Application by Snowdonia Pumped Hydro Limited for an Order Granting Development Consent for the Glyn Rhonwy Pumped Storage Scheme

Request for further information schedule

Issued on 26 August 2016

Figure 3.3: Nuttall's waterweed control options decision tree

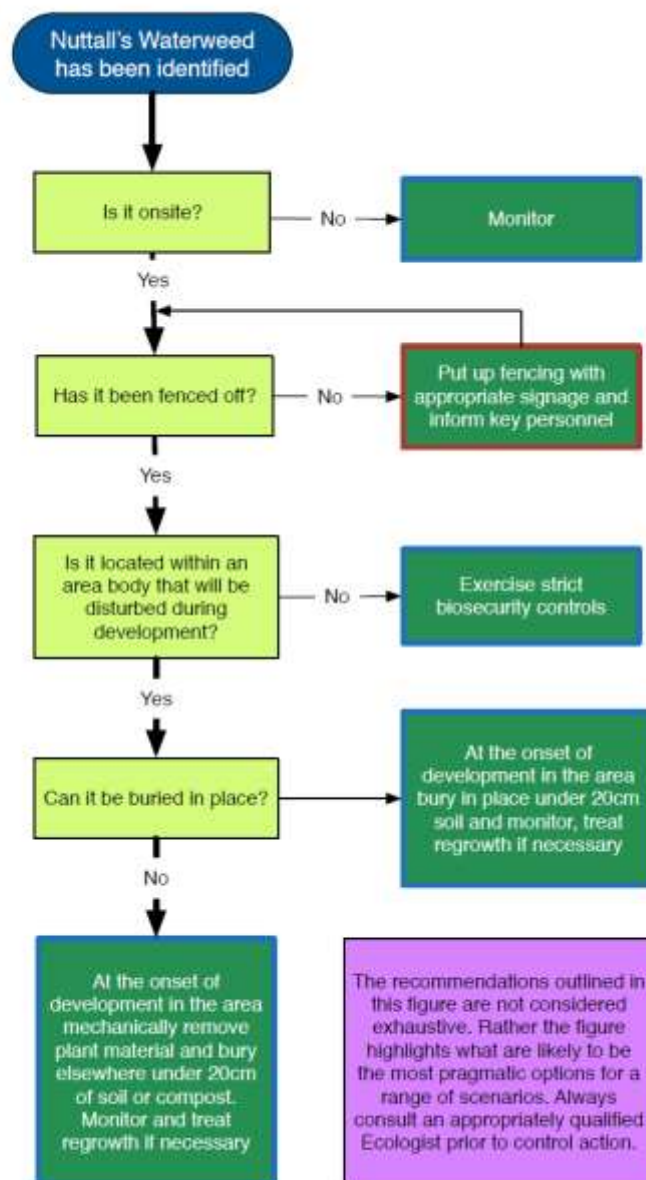
3.4.	Applicant	<p>Ref: Applicant's [REP7-004] response to ExA's rule 17 request of 20th July 2016 [PD-025, request 3.10].</p> <p>The Applicant appears to have misinterpreted request 3.10 (b) [REP7-004]. Please could the specific relevant mitigation measures required to address the risks of Nuttall's waterweed in Llyn Padarn being disturbed during construction or operation and the risks of it being abstracted to the reservoirs, either during the initial filling or in the future, be described more fully in the Biosecurity Plan [REP7-018]?</p>
